# ***City of Albuquerque***

**RE: ENGINEER'S CERTIFICATION FOR COMFORT INN MOTEL (H-11/D29A)  
RECEIVED MARCH 11, 1996 FOR CERTIFICATE OF OCCUPANCY  
ENGINEER'S STAMP DATED 3/6/96**

PROJECT TITLE: Comfort Inn ZONE ATLAS/DRNG. FILE #: H-11/029A

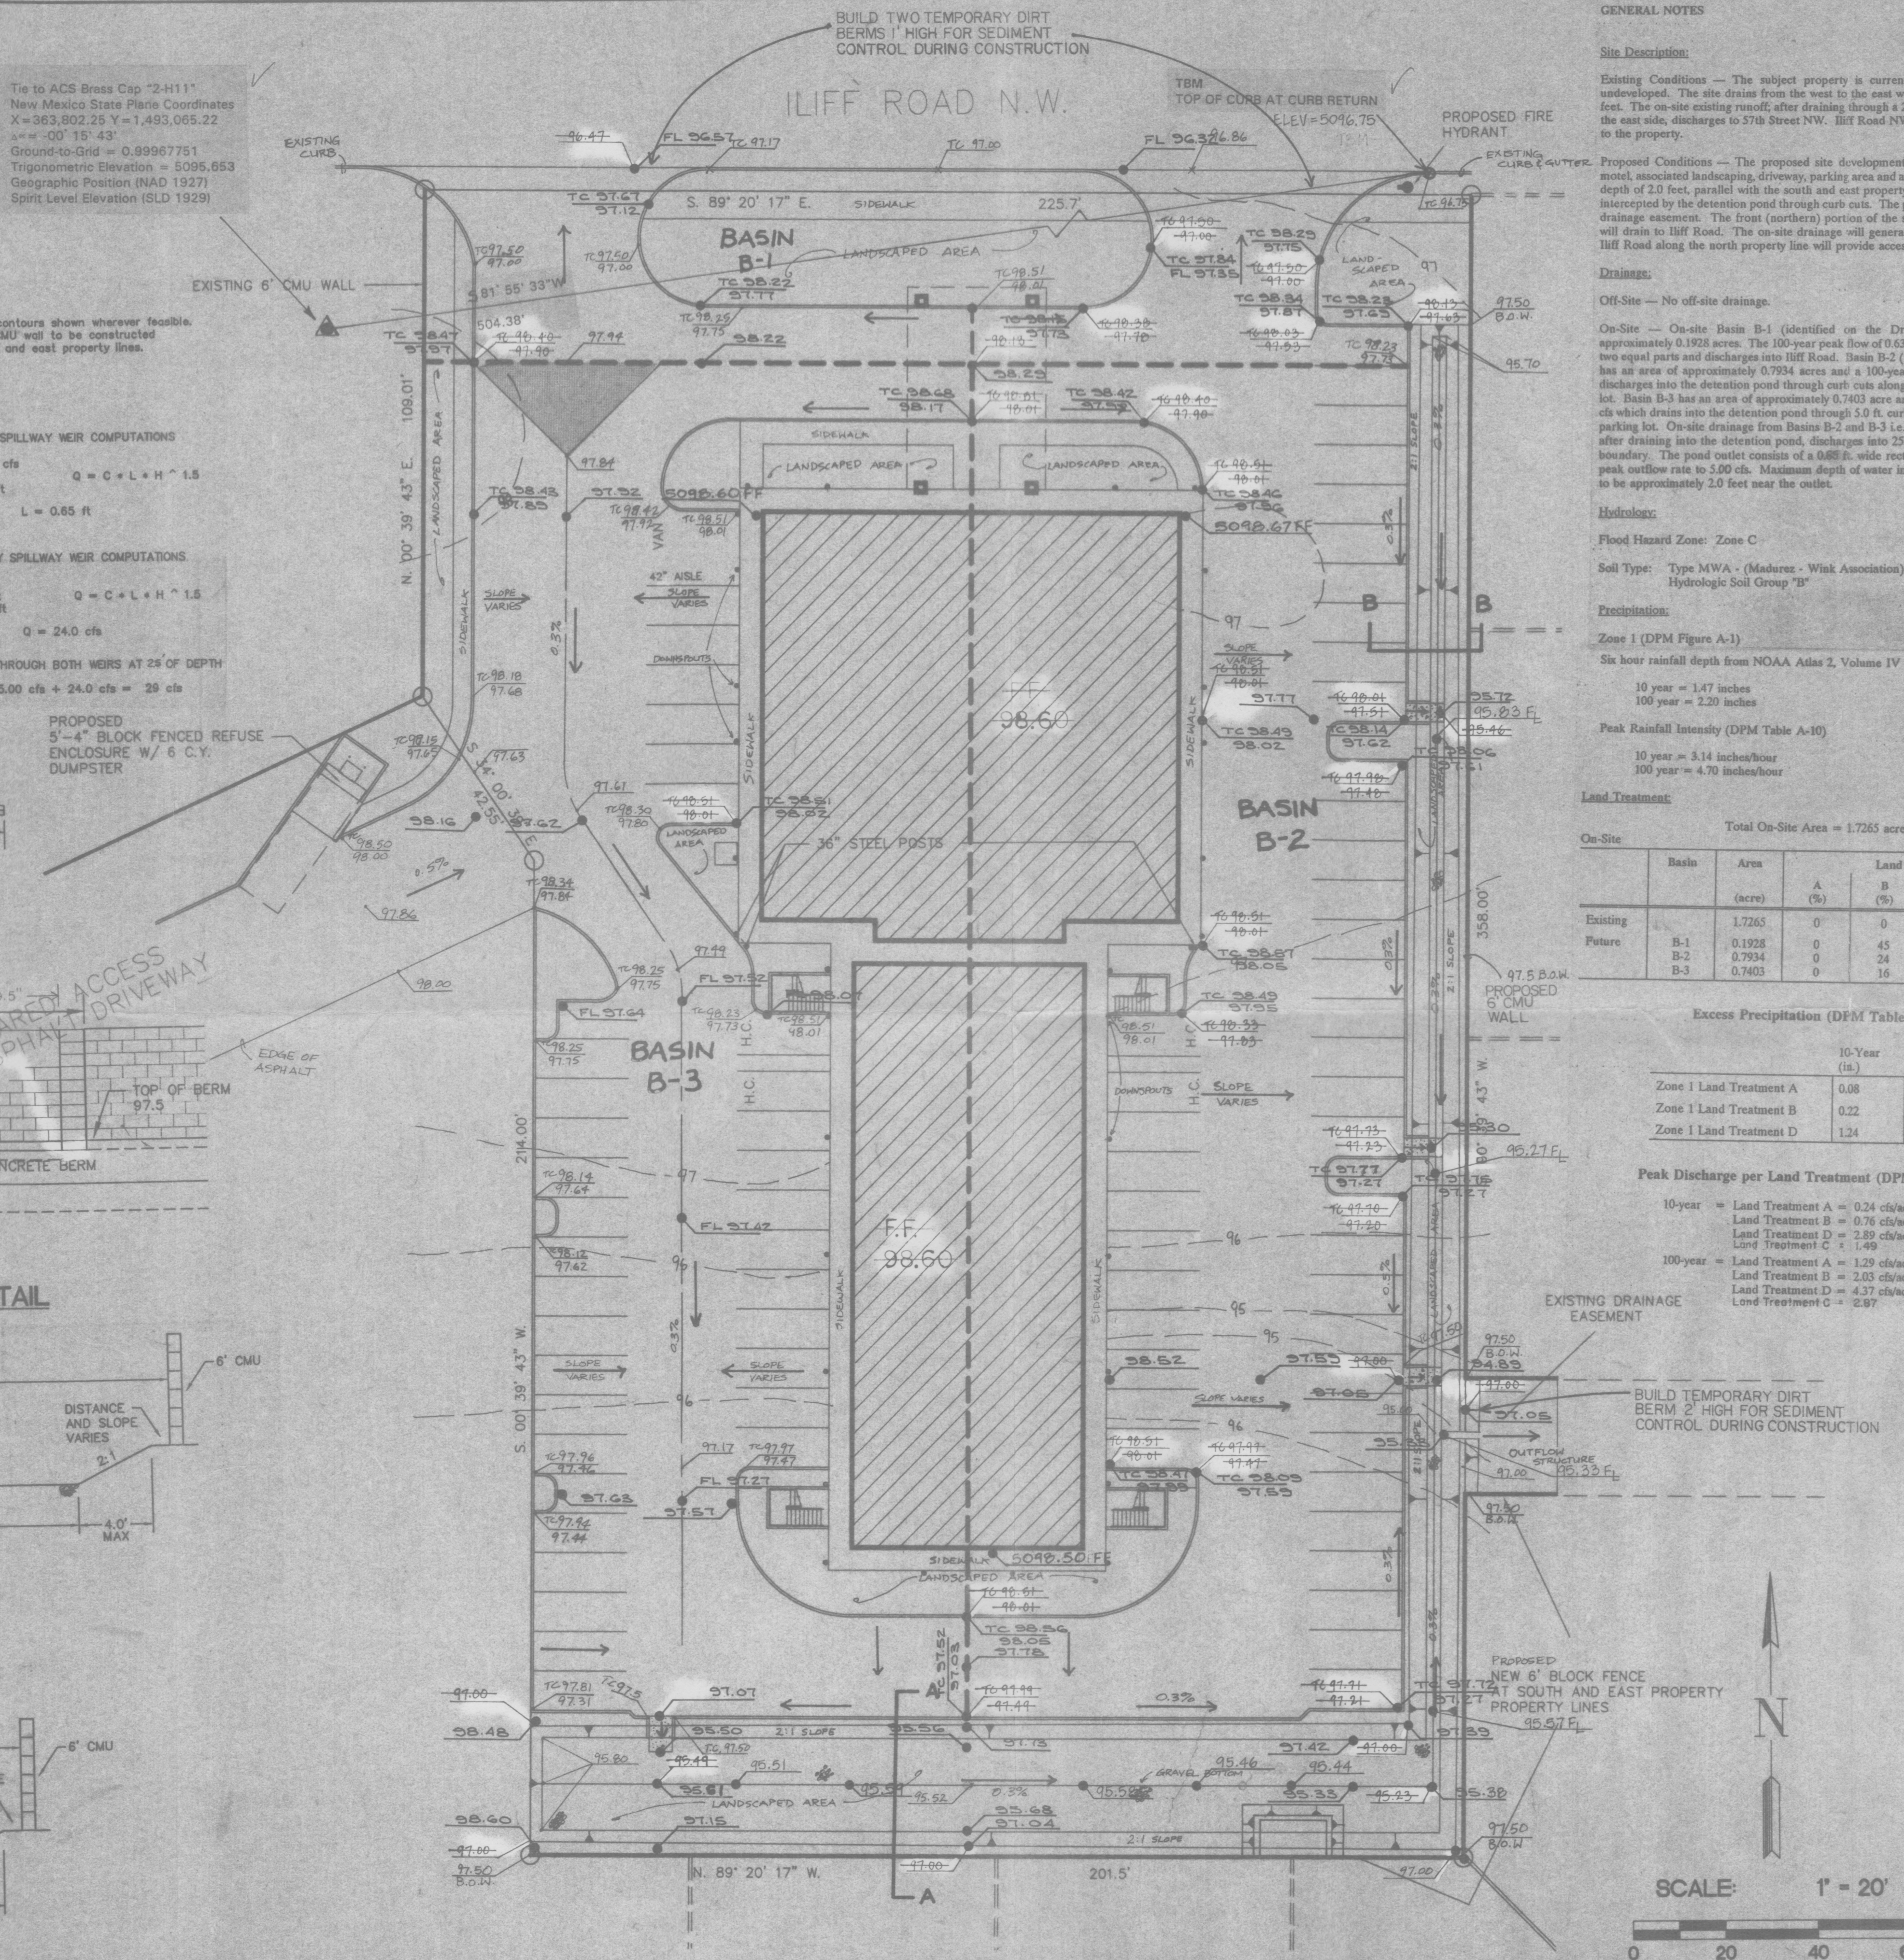
**The Bench Mark data is missing from the Plan. Indicate the location, description, and elevation of the Albuquerque Control Survey Vertical Datum and the temporary on-site bench mark on the Plan. Indicate the complete Mean Sea Level designation of the finish building floor elevations. When both proposed & as-built elevation are indicated at the same spot, put a line through the proposed elevation.**
